Cc: Luke Honeywill [REDACTED]
Subject: RE: AL/68/20/DOC

From: Maria Tomalova <Maria.Tomalova@arun.gov.uk>
Sent: 28 October 2020 18:15
To: Office [REDACTED]
Subject: AL/68/20/DOC

We have received the comments from Drainage Engineers with regards to the discharge of conditions 10 and 11, subject to the above application:

| DRAWING TITLE<br>DRAINAGE LAYOUT          |            |          |            |             |     |

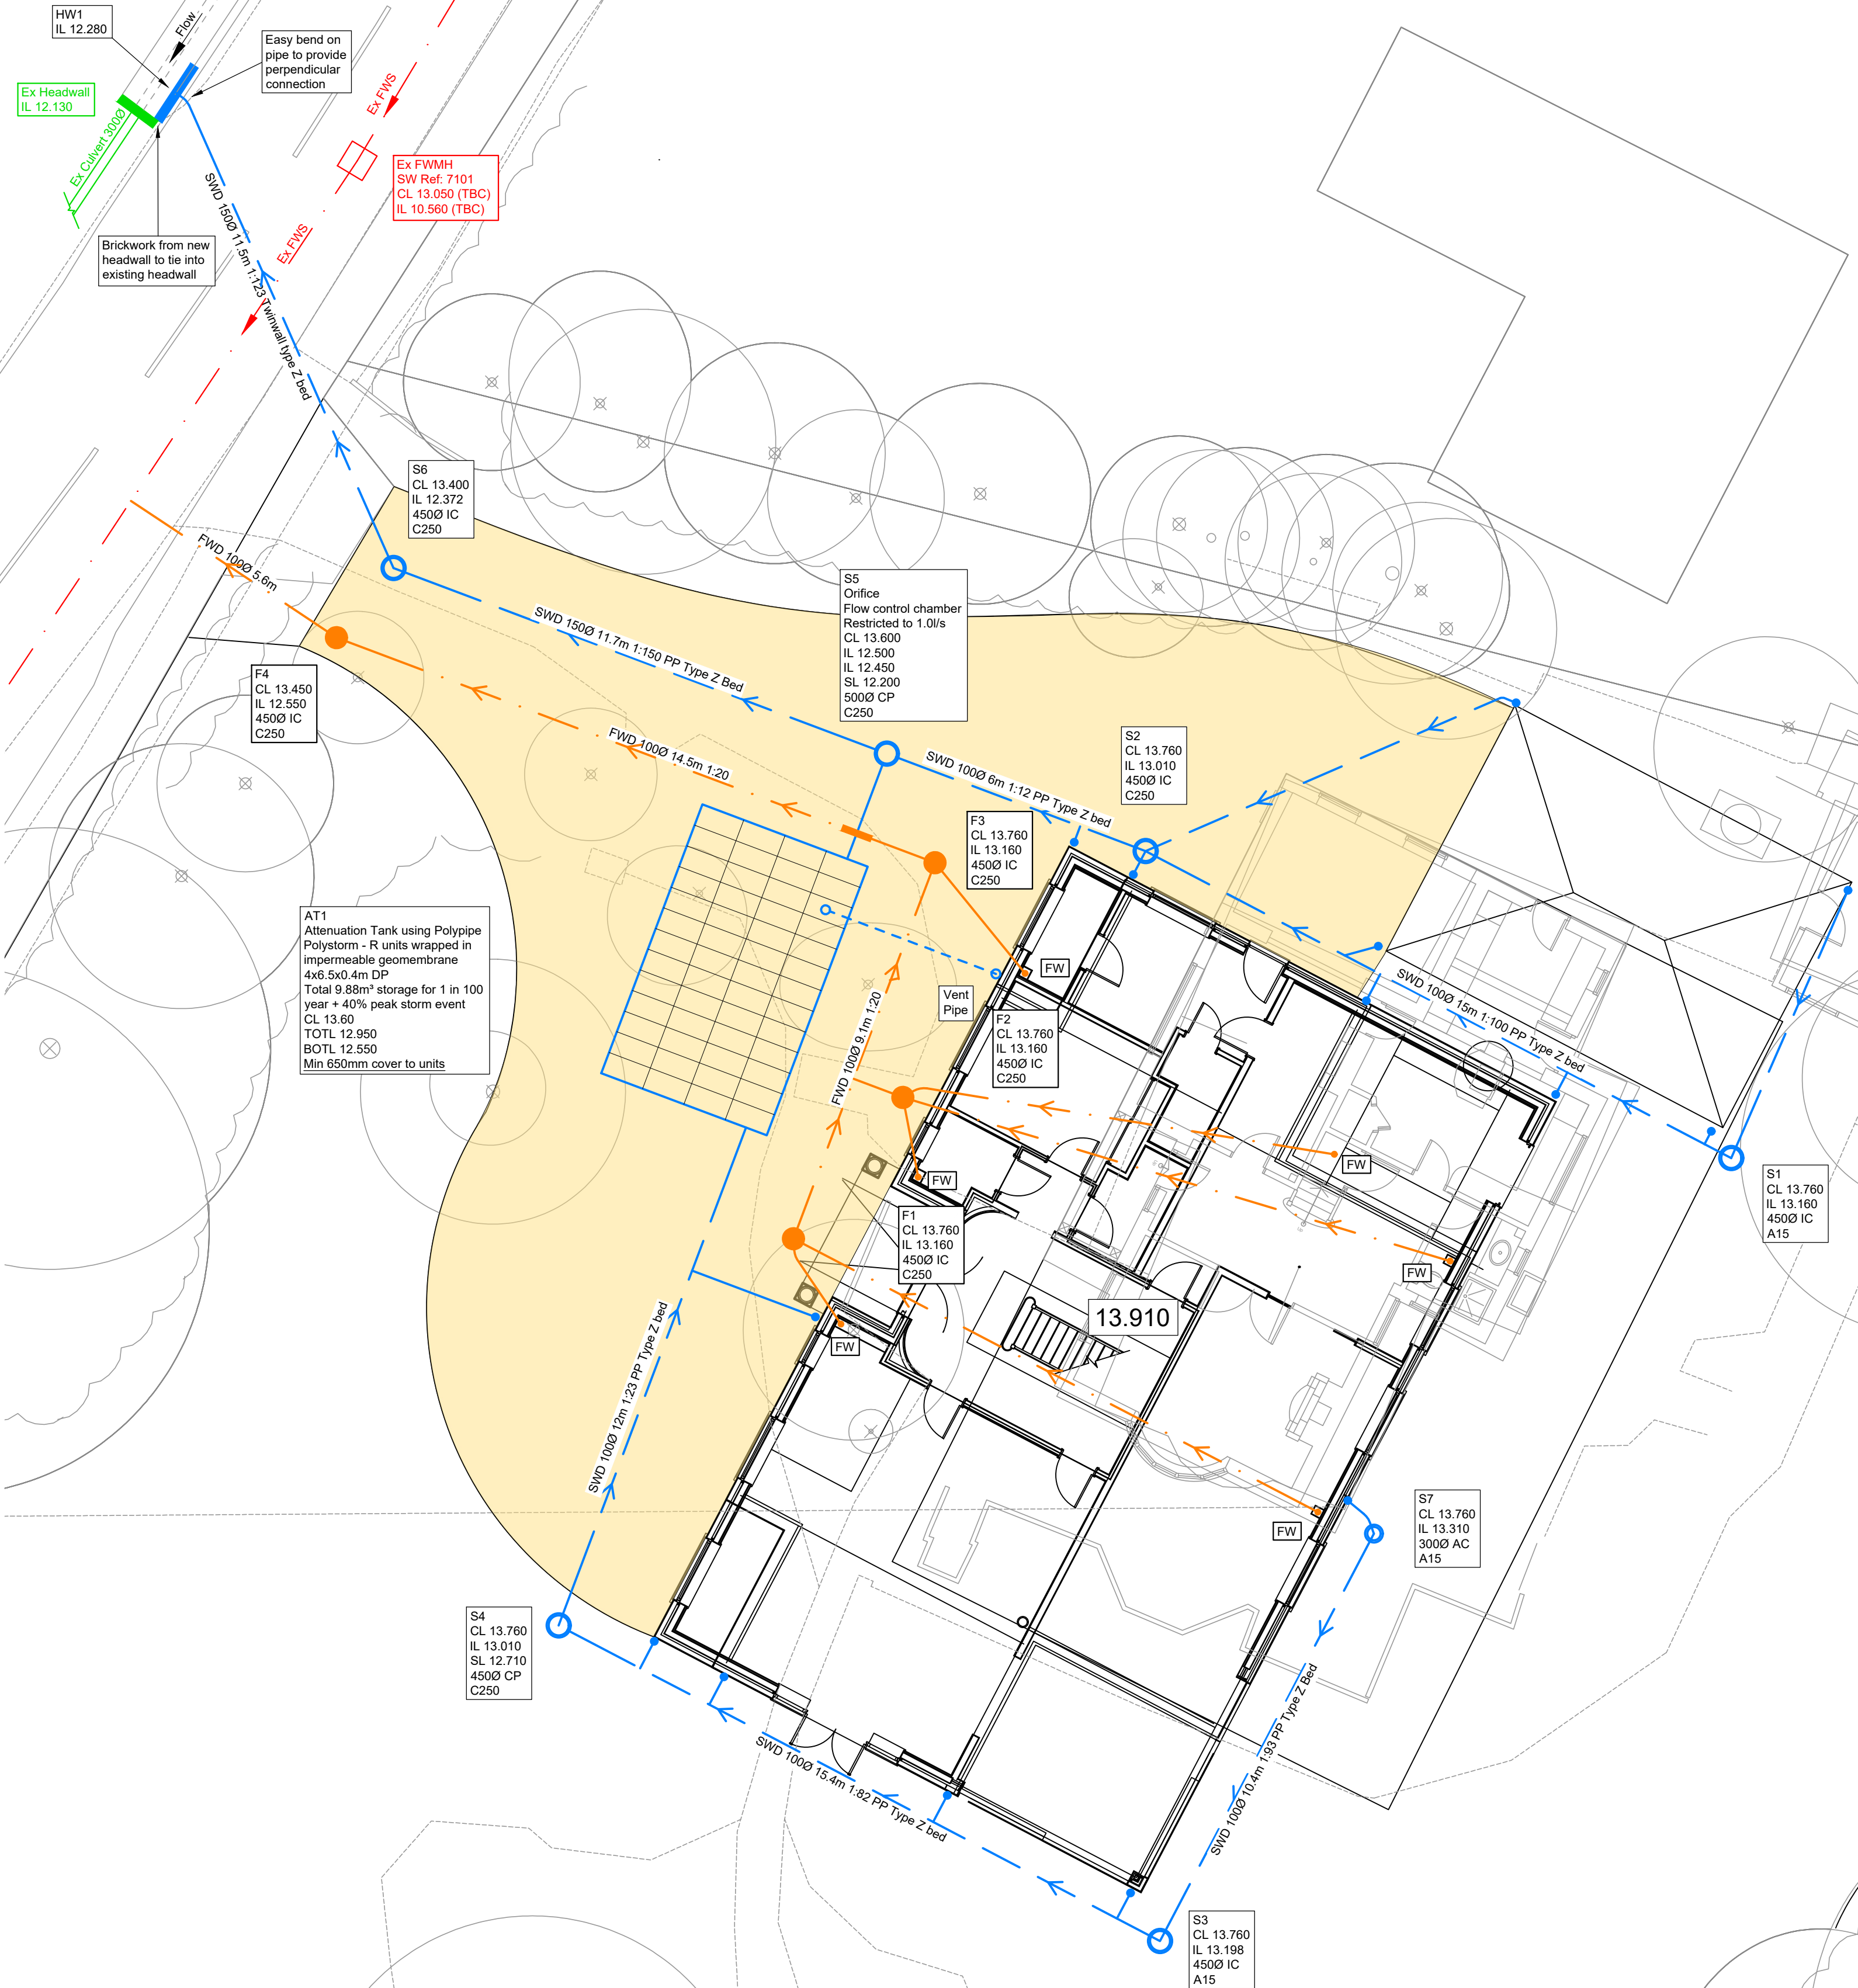
'We recommend this application to discharge conditions 10 and 11 is refused. Until it is demonstrated that the site can be drained to an acceptable discharge location it is not possible to approve drainage proposals under this discharge of conditions application. Any alterations to discharge location, or point of connection, will impact upon the wider proposed drainage scheme. It is essential to know the discharge location to be able to assess whether proposals are adequate and will not increase flood risk elsewhere.

Just to inform you we have submitted our revised information to Paul Cann to approve which we're confident will happen with this latest design.
